## **Great North Road Solar and Biodiversity Park**

Draft Statement of Common Ground with Nottinghamshire County Council

Document reference – EN010162/APP/8.1

December 2025

Great North Road Solar and Biodiversity Park Environmental Statement

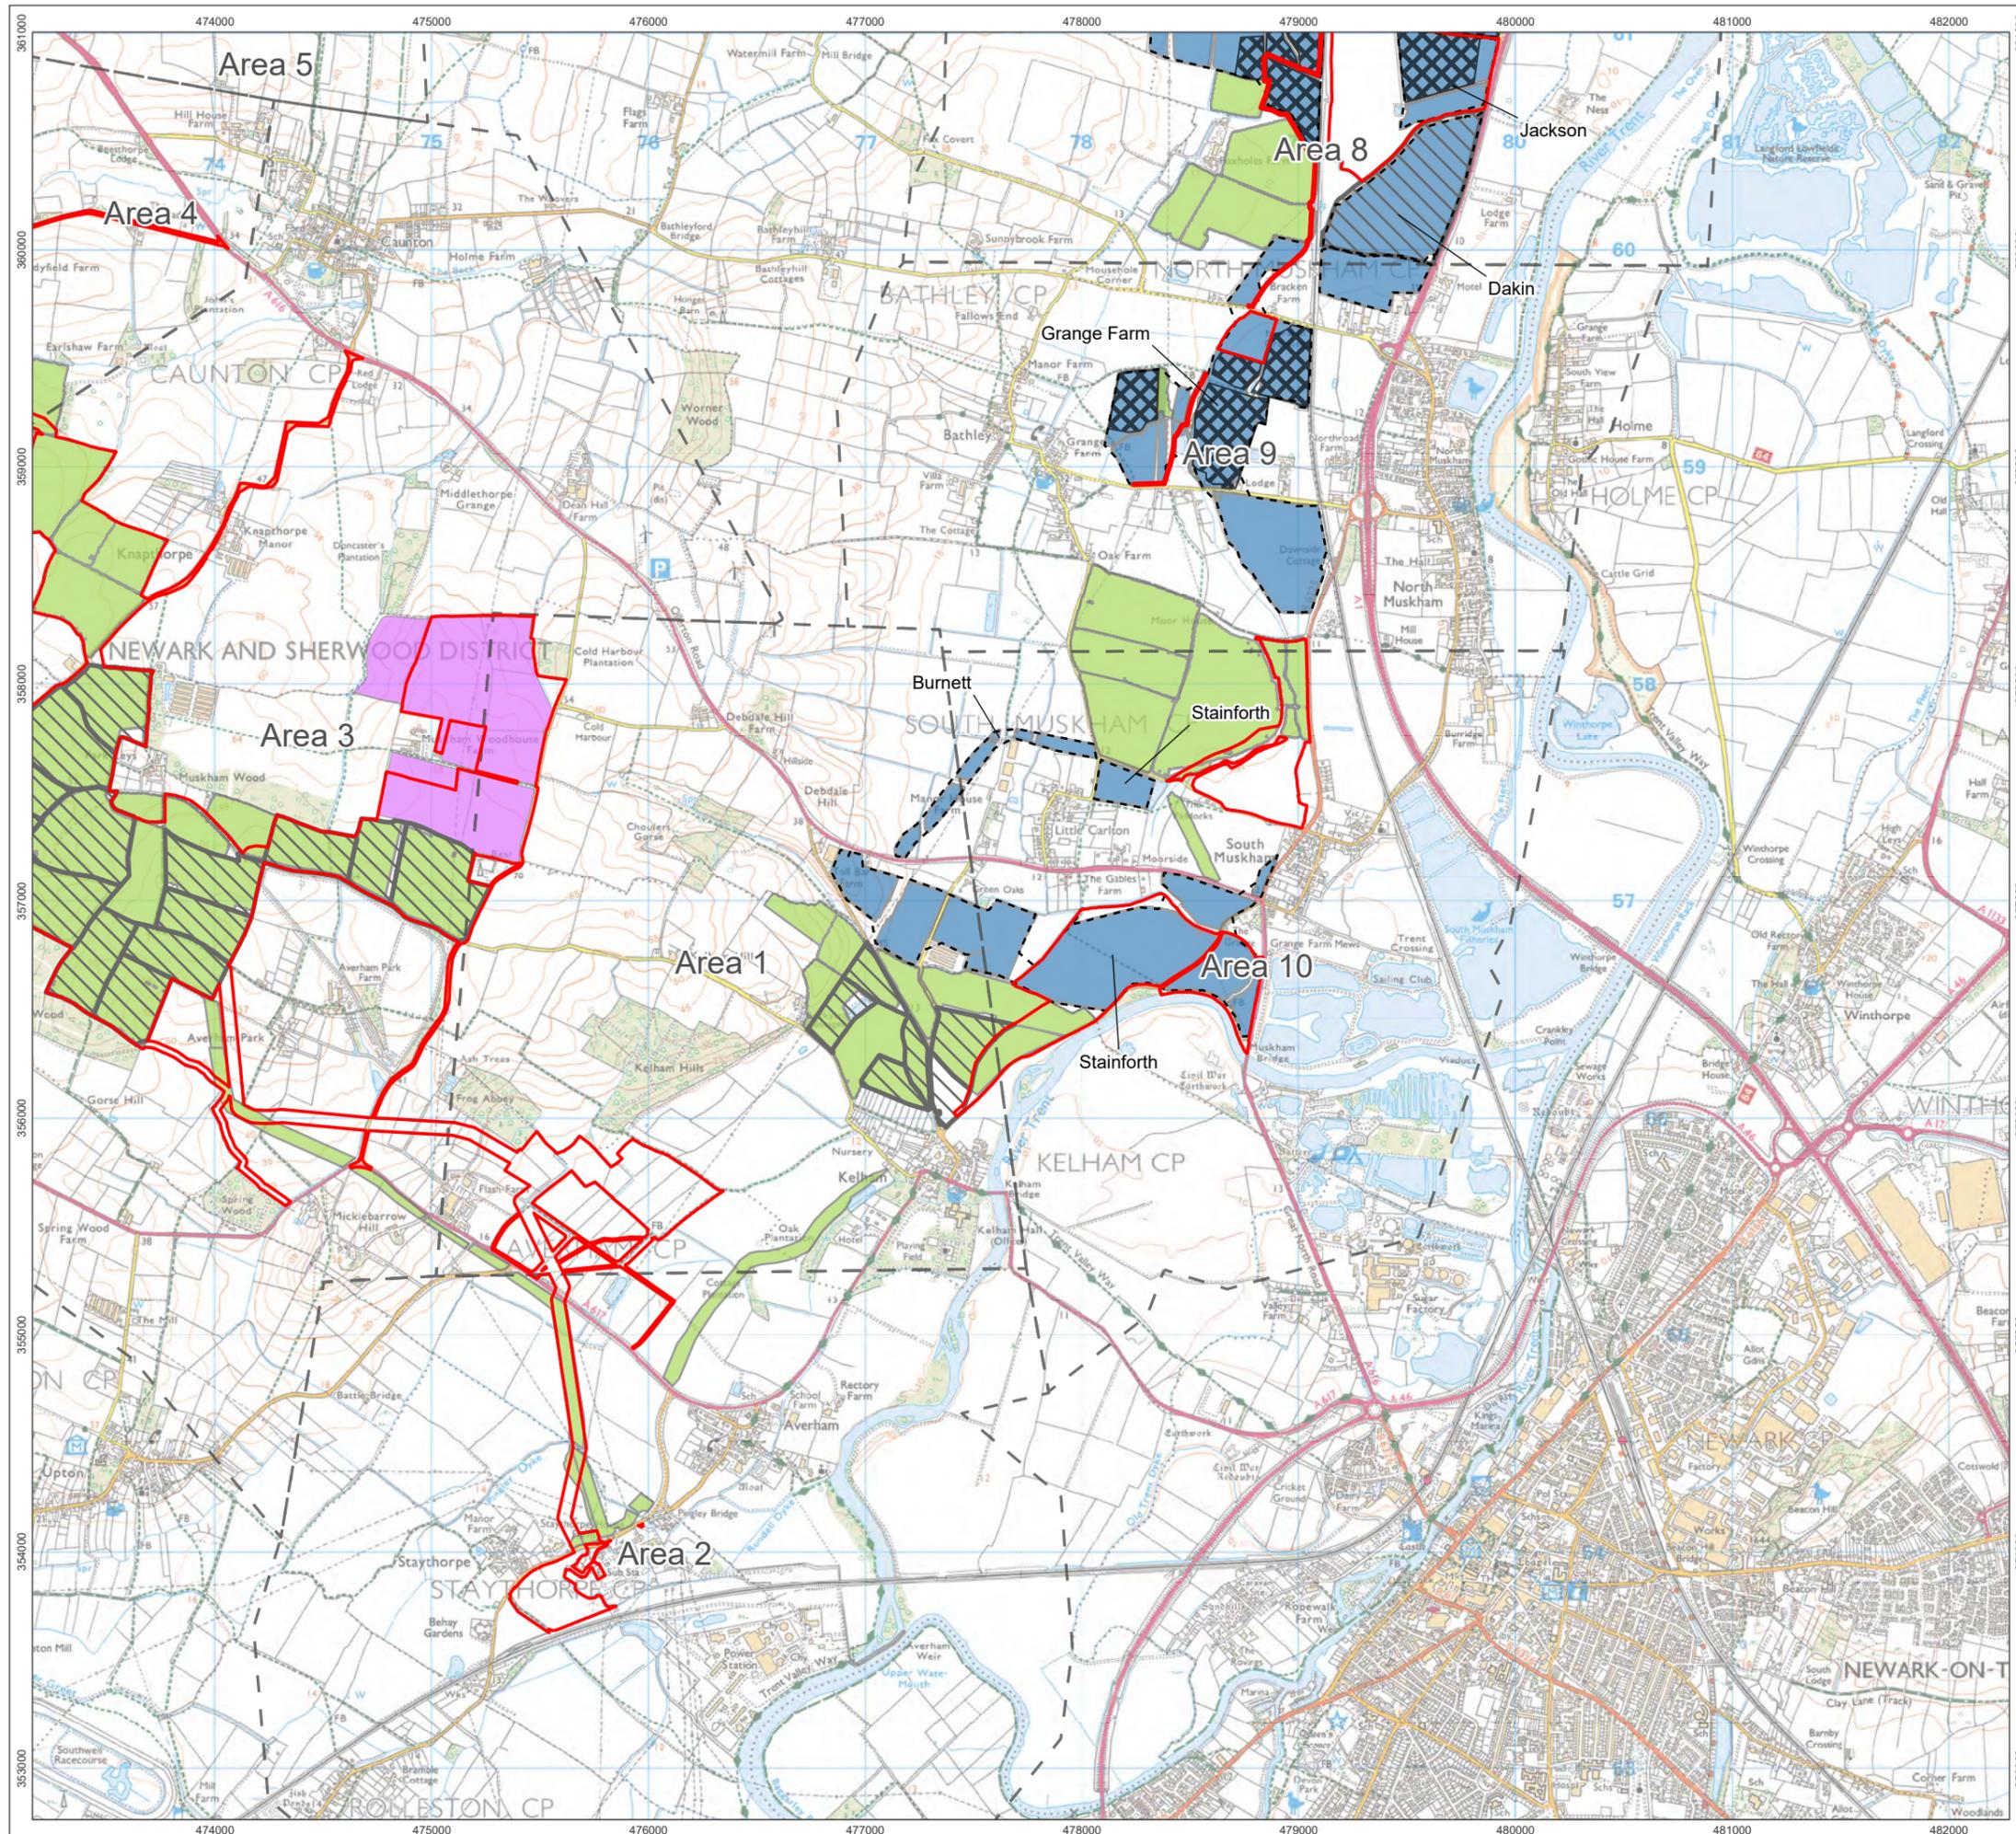
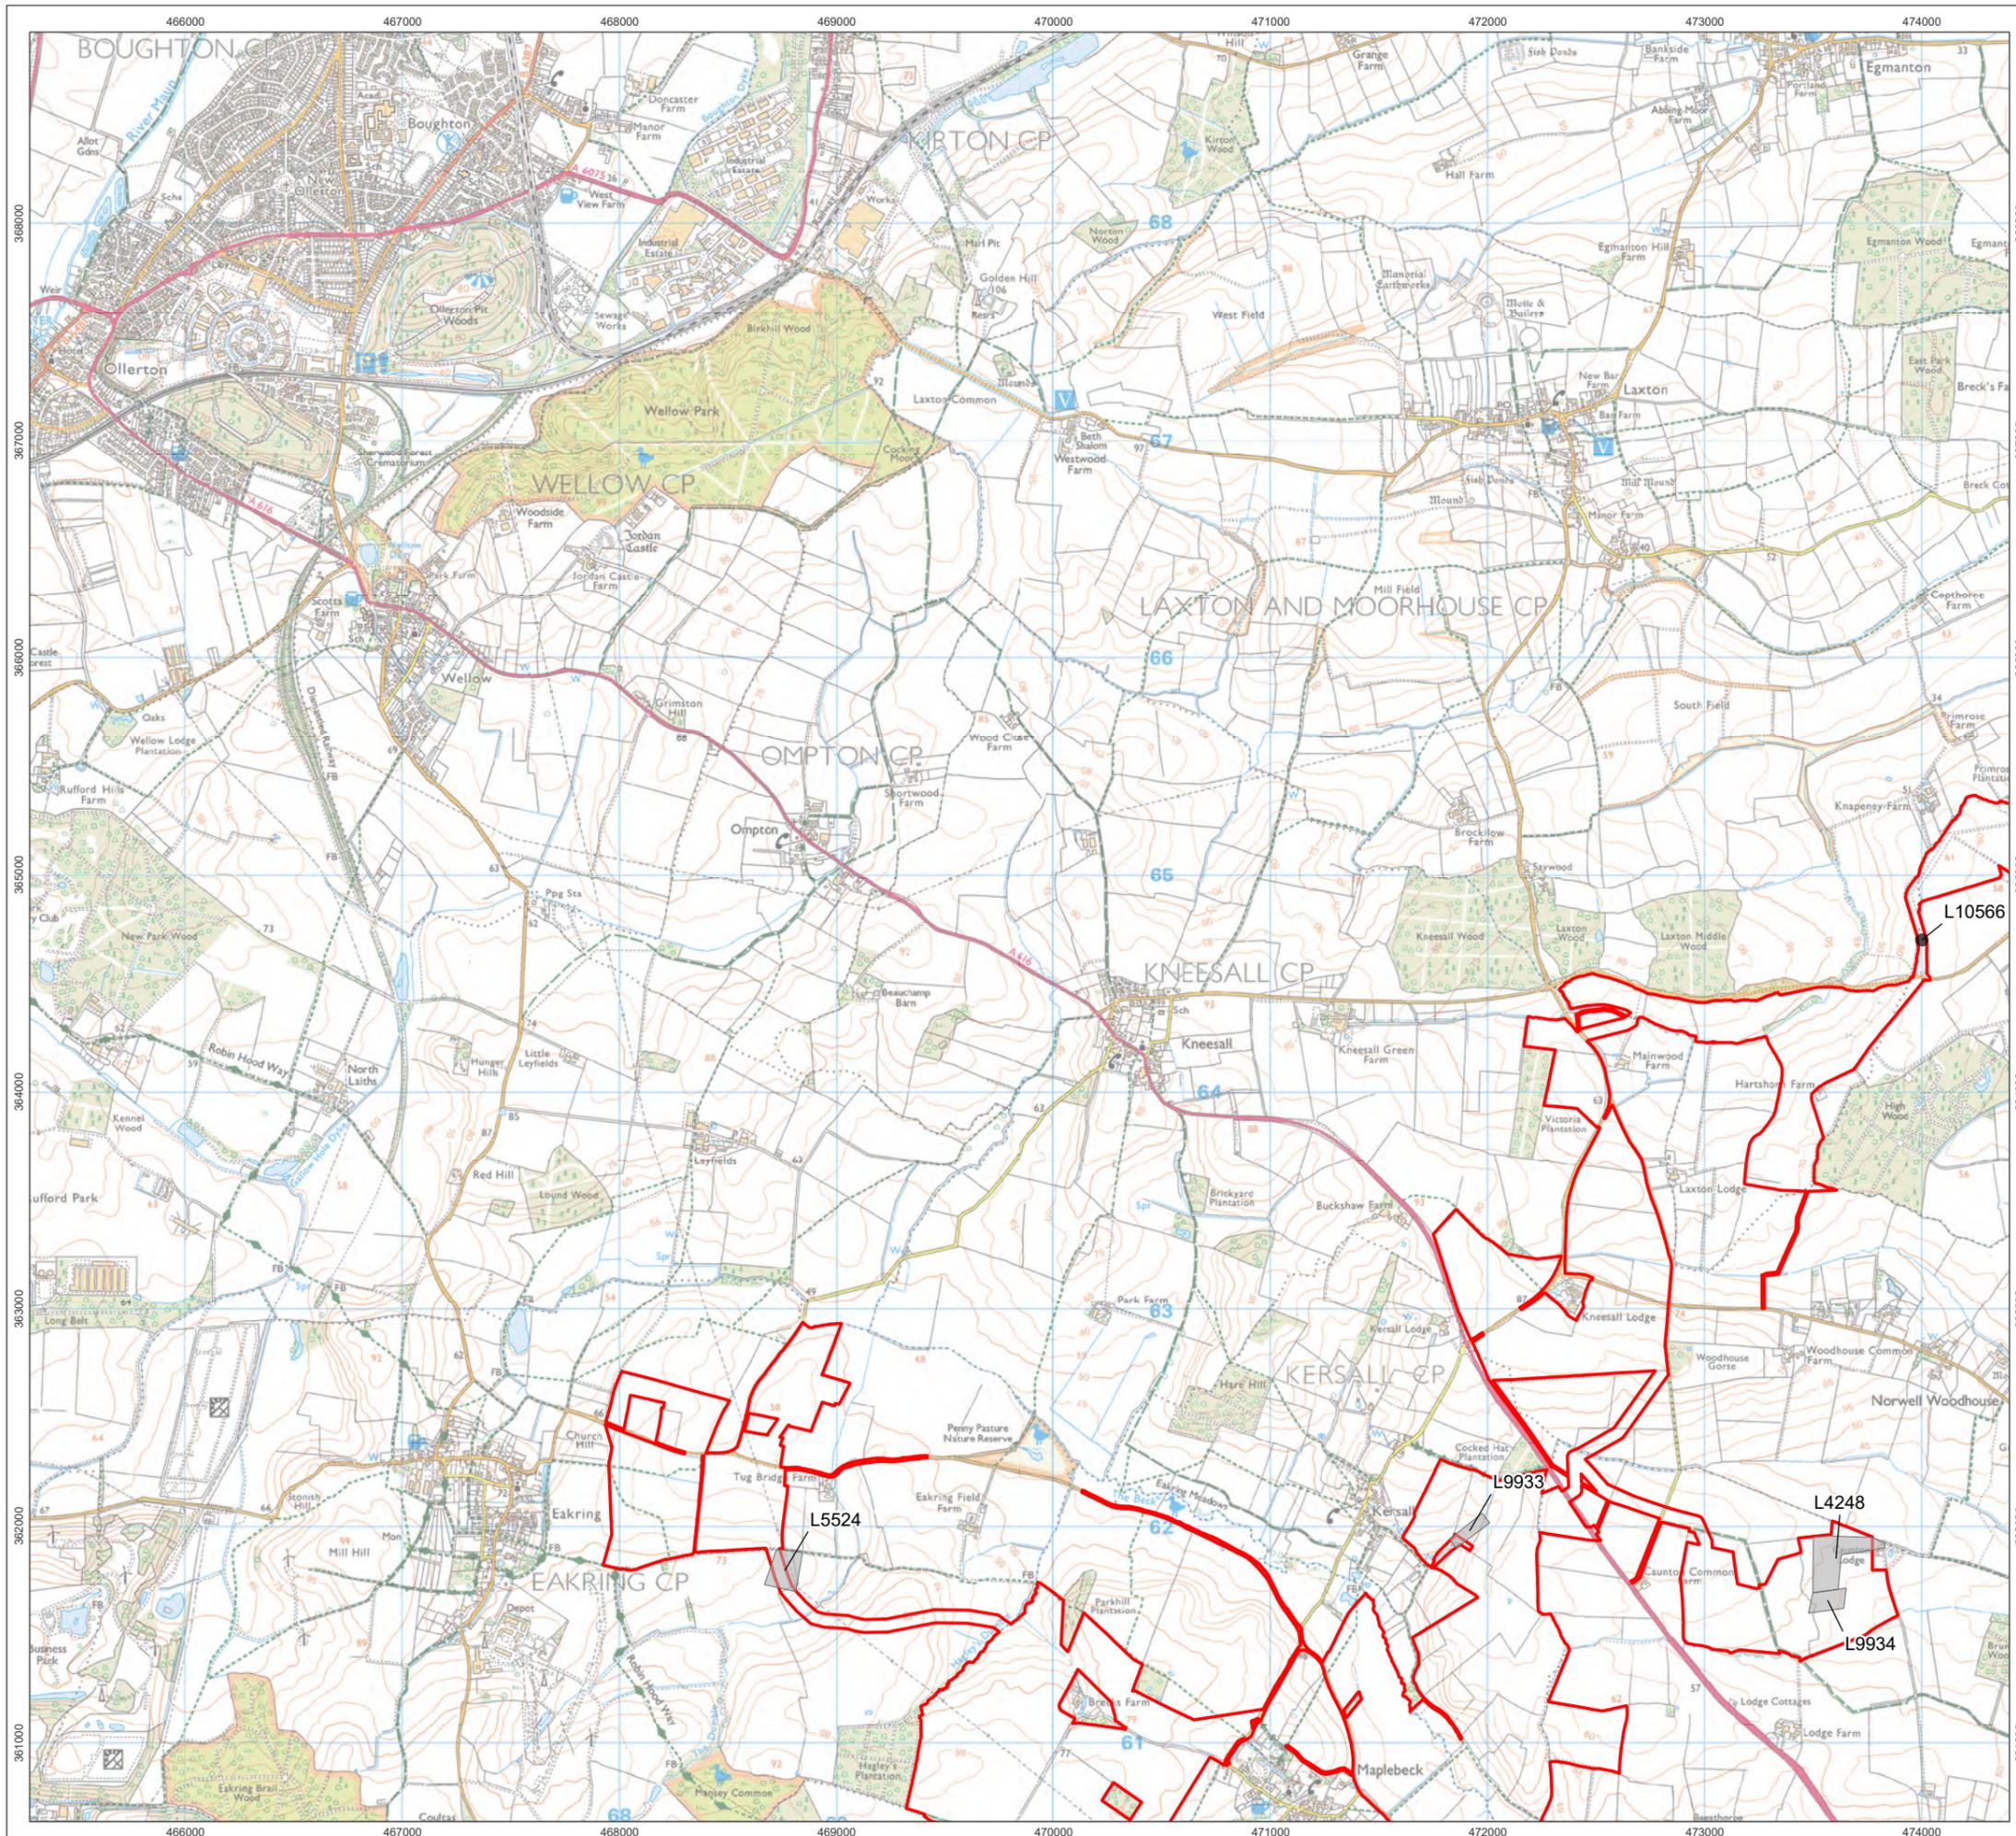
2.2.6	RR	AMS (Trial trenching)	<p>The statement that the archaeological assessment work to date has been largely sufficient to provide an acceptable level of data to inform the ES is welcomed.</p> <p>In regard to the completeness of survey to date it should be noted that geophysical baseline survey coverage was c.90% and that trenching tested all geologies. This is considered to be proportionate, in line with developing best practice guidelines and sufficient to inform the ES.</p>	We welcome the archaeological assessment work undertaken to date and broadly welcome the approach undertaken by the applicant. The desk-based assessment covers the full site and the geophysical survey has been undertaken on the majority of the order limits. This has been largely sufficient to provide an acceptable level of data to inform the baseline for the Environmental Statement (ES) and an initial phase(s) of trial trench evaluation.	Under Discussion

Ref	Relevant Documents	Description of Matter	Applicant's Position	NCC's Position	Status
			<p>The scope of post-consent investigation, provision for which is set out in the OAMS, will be agreed through continued engagement with NCC during the period of the examination.</p> <p>It is expected that the post-consent investigation and subsequent mitigation will be developed in line with emerging best practice as set out in Archaeology and Solar Farms: Good Practice Guide:</p> <p><i>A toolkit for developers, archaeological advisors, consultants and contractors.</i></p>	<p>However, the applicant acknowledges that the geophysics results have not been tested in their entirety (Para. 48) which we consider a serious limitation when undertaking an appropriate assessment and gathering sufficient data to inform significance and impact.</p> <p>However, the OAMS has made provision for post consent geophysics and trial trench evaluation work that will potentially resolve the above issue if implemented appropriately. The OAMS has left the scope of this work to be agreed.</p> <p>We appreciate that solar farm development differs slightly from other development types and that some elements will not be fixed until post consent. While we maintain our position that the assessment work should be completed as part of the application/examination process to inform design, we</p>

Ref	Relevant Documents	Description of Matter	Applicant's Position	NCC's Position	Status
				<p>accept that some evaluation work could be left until the detailed design has been fixed and when areas of higher impact can be properly targeted for intrusive evaluation. For instance, panel arrays may have a relatively low impact if cables are clipped up behind rather than buried in trenches behind, and details on this will help influence the level of intrusive evaluation required to characterise the archaeology and assess impact.</p> <p>During the examination period, we would expect to further refine the OAMS in consultation with the applicant and their consultants and agree an outline programme for the post-consent completion of the assessment work. There will also need to be specific wording included in the DCO with respect to the archaeology requirement which secures completion of the assessment work and provision for an</p>

Ref	Relevant Documents	Description of Matter	Applicant's Position	NCC's Position	Status
				<p>updated AMS and its timely implementation prior to any construction work being undertaken.</p> <p>We are confident that these issues can be resolved with the applicant and their consultant if they continue to engage with us by the end of examination.</p>

**2.2.1 Applicant Response:** For background and context, EN-3 confirms that appropriate desk-based assessment, and where necessary, a field evaluation, in consultation with the local planning authority, should identify archaeological study areas and propose appropriate schemes of investigation, and design measures, to ensure the protection of relevant heritage assets (paragraph 2.10.113).

- 2.2.5 The Applicant completed a desk-based assessment and a full geophysical survey was undertaken covering the areas where physical development is proposed within the Order limits to establish a baseline understanding of the potential for sub-surface archaeology. The Applicant recognised and responded to comments raised by the County Archaeologist. To mitigate this the Applicant has included flexibility in the Works Plans to relocate Development elements and/or utilise non-invasive installation methods (ballast) to avoid any impact on sub-surface archaeology.

- 2.2.6 In addition, the Applicant has completed a number of targeted trenches and boreholes, which have been discussed and agreed with the County Archaeologist. These have been targeted to the areas of greatest archaeological potential identified during the desk-based assessment and geophysical survey and also where the geophysical survey had interpreted discoveries as being of likely geological origin rather than archaeological interest and in areas where there was no specific intelligence to suggest archaeology, but to test the quality of the geophysical survey. The quantity of evaluation trenching is considered to be proportionate at this stage and further evaluation will take place post-consent as detailed in the **Outline AMS (TA A11.8 [EN010162/APP/6.4.11.8]) [APP-269]** (see Section 11.7).
